Development Control
Ribbles Valley Borough Council

Re: Planning Application 20/0689

Address: Banks Cottage Chipping Road Longridge PR3 2NB

Description: Formation of new vehicular access drive, stone garden wall and (vehicular and pedestrian) gates to replace the existing drive. Formation of new detached garage workshop and garden store. Remodel and resurfacing of the existing site to improve vehicle access, parking and manoeuvring. Resubmission of 3/2020/0246.

NEW VEHICLE ACCESS & DETACHED GARAGE/ GARDEN STORE BANKS COTTAGE, LONGRIDGE, PRESTON LANCASHIRE PR3 2NB	JM-0182	004-C
	PROPOSED SITE PLAN SK1	Date: 30.01.20 Drawn: J Monks Scale: 1:200 Size: A3
MONKS-ARCHITECTURAL-DESIGN 25 BIRCHFIELD DRIVE - LONGRIDGE- PRESTON - PR3 3HP

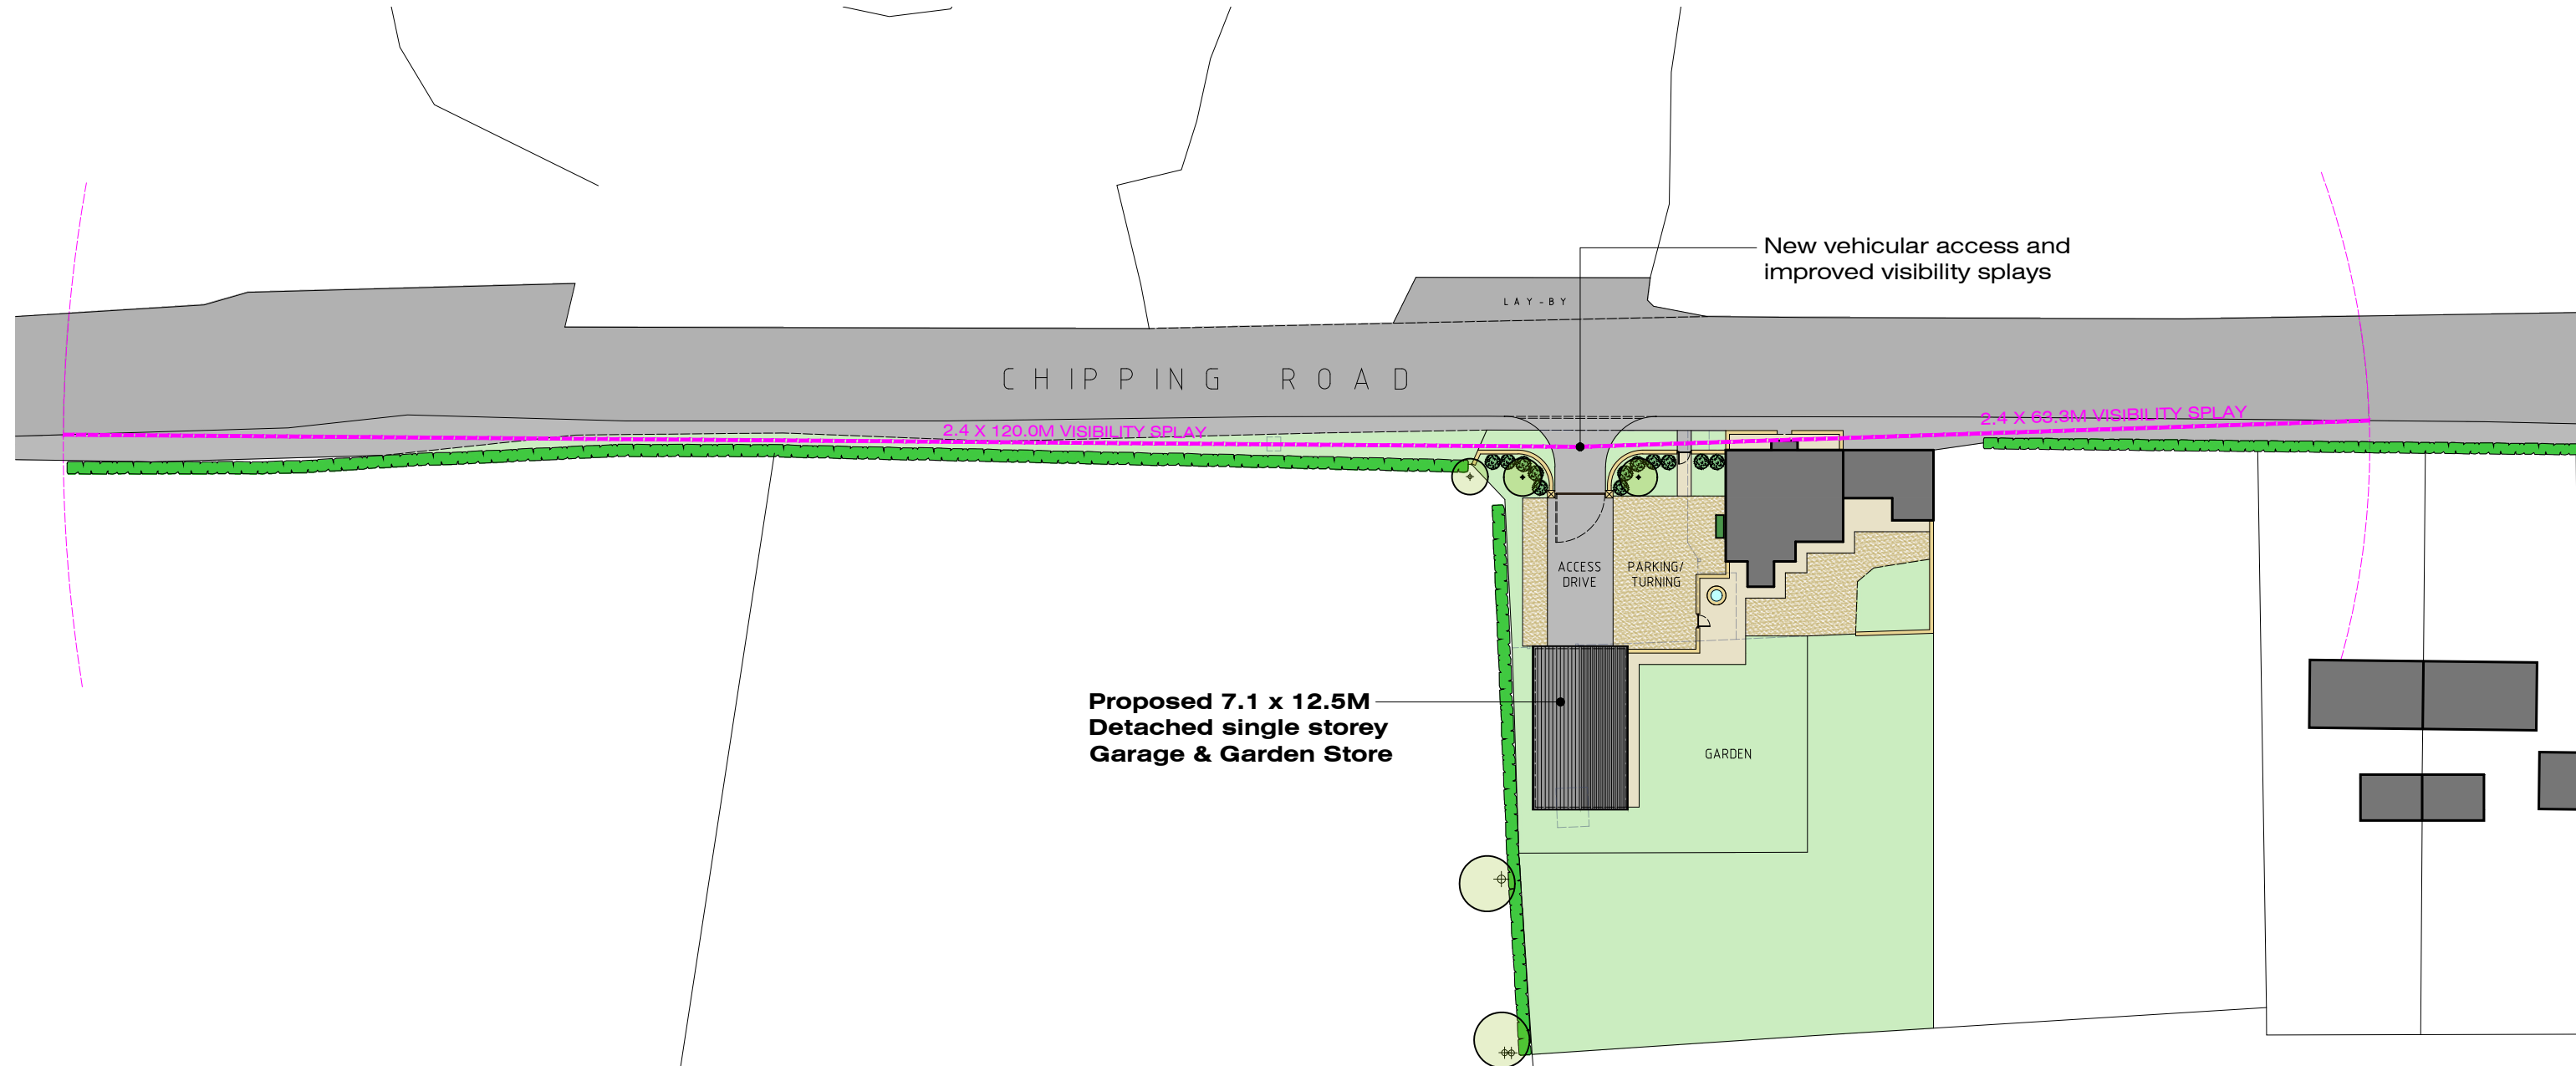
Whilst the improved visibility splays may not be to the required length as would suggested by the anticipated speed of the passing traffic, they are an improvement on the existing situation. As far as we are aware there have been no reported collisions in the area in the last five years.

NEW VEHICLE ACCESS & DETACHED GARAGE/ GARDEN STORE BANKS COTTAGE, LONGRIDGE, PRESTON LANCASHIRE PR3 2NB	JM-0182	005-C
	PROPOSED SITE PLAN-2	Date: 30.01.20 Drawn: J Monks Scale: 1:200 Size: A3

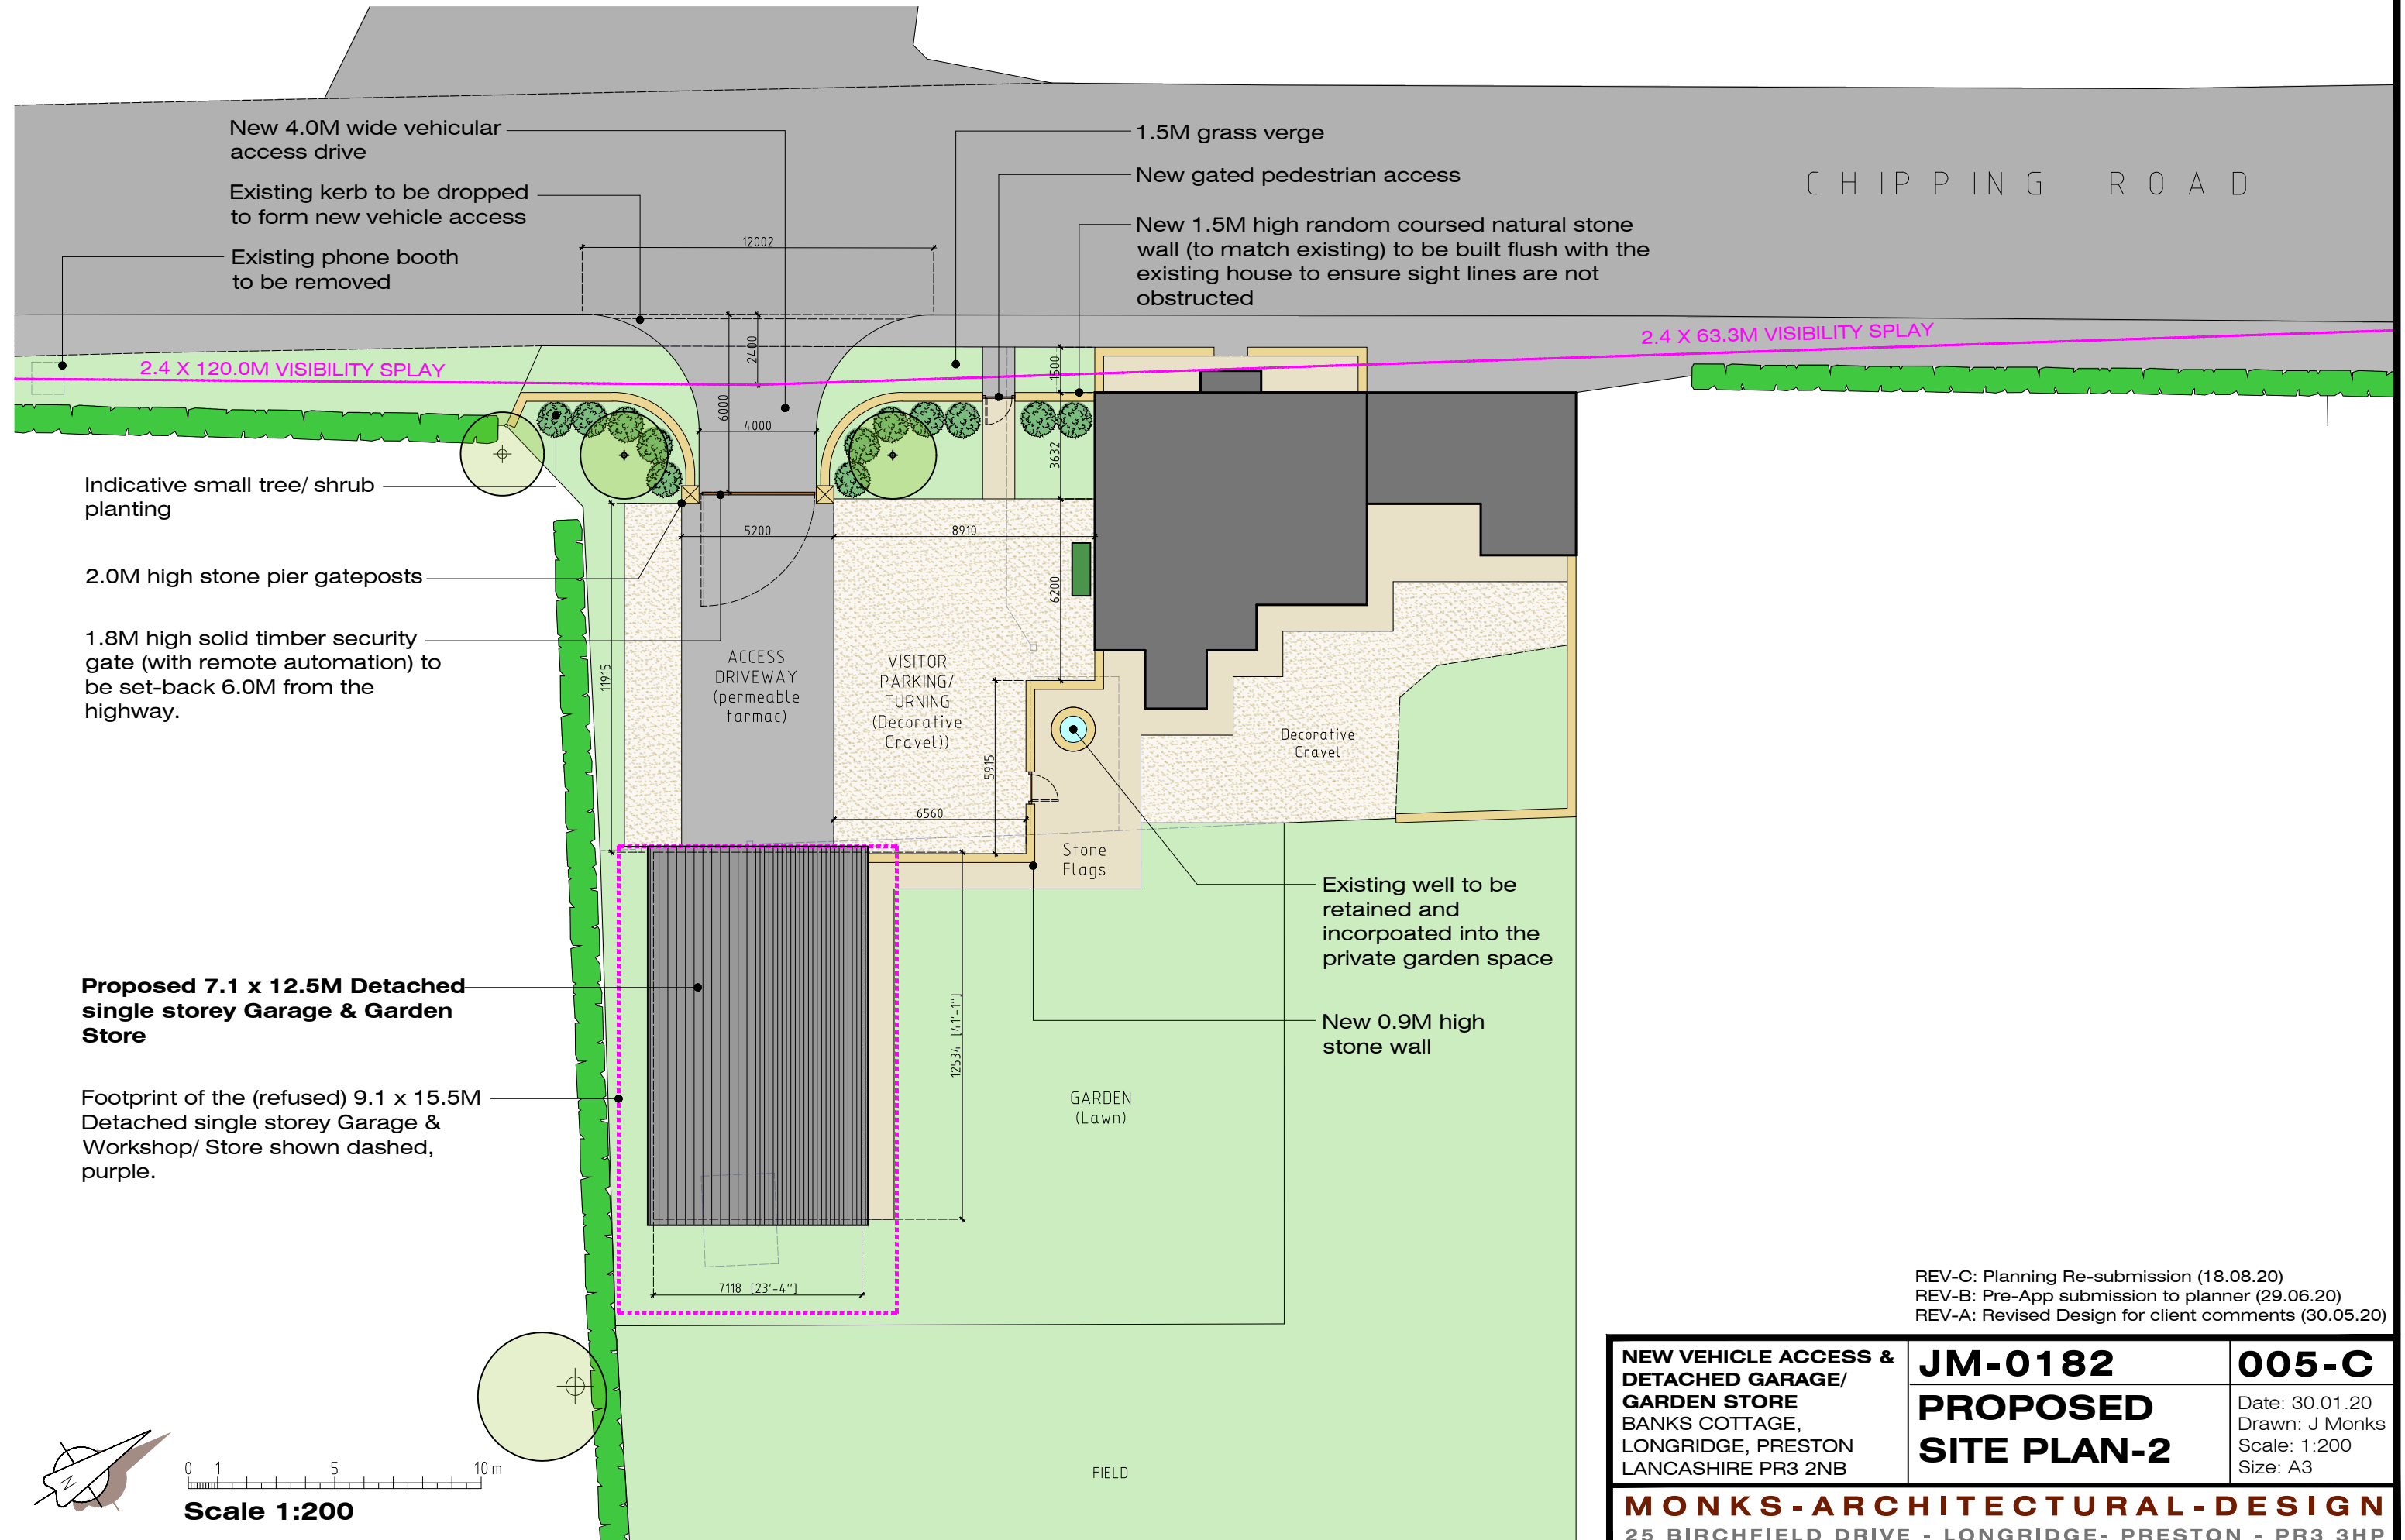
1. Before the access is used for vehicular purposes, any gateposts erected at the access shall be positioned more than 5m behind the back edge of the carriageway. The gates shall open away from the highway. **Reasons:** To permit vehicles to pull clear of the carriageway when entering and exiting the site and to ensure the swing of the gates do not affect the availability for a car to wait off road.

2. All gates and associated mechanisms to be located outside the adopted highway and the gates to have physical restraints to prevent the gates from opening onto the adopted highway. **Reasons** to ensure the adopted highway is not obstructed by the gates or are a hazard to other road users.

5. Before the access is used for vehicular purposes, that part of the access extending from the highway boundary for a minimum distance of 5m into the site shall be appropriately paved in tarmacadam, concrete, block paviments, or other approved materials. **Reasons:** To prevent loose surface material from being carried on to the public highway thus causing a potential source of danger to other road users
